Consultation Response from KC,
Highways Development Management

2024/93226 land at, St Luke's, Bierley Marsh, East Bierley, BD4 6PL

Discharge of details reserved by conditions 3 (Ecological Design Strategy), 4 (Condition Survey of Bierley Marsh), 6 (Construction Management Plan), 7,9 (Intrusive Investigation Phase2 SI), 14,15 (Boundary Treatment, Hard and Soft Landscape) on previous permission 2020/94345 (APP/Z4718/W/21/3289729) for erection of 5 dwellings

Date Responded:7-1-2025.

PRE-CONDITION SURVEY ON BEHALF OF OWENS DEVELOPMENTS LTD

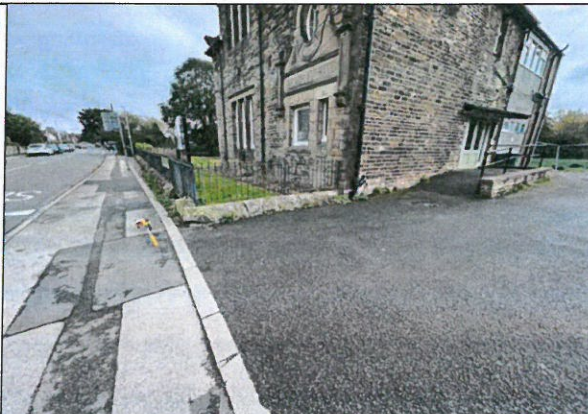
A pre-condition survey is provided by MCB Highways Solutions which show points of detail along the length of road to be surveyed but generally excludes the condition of the Bierley Marsh carriageway.

Further detail should be provided showing the condition of the Bierley Marsh carriageway.

This condition should not therefore be discharged.
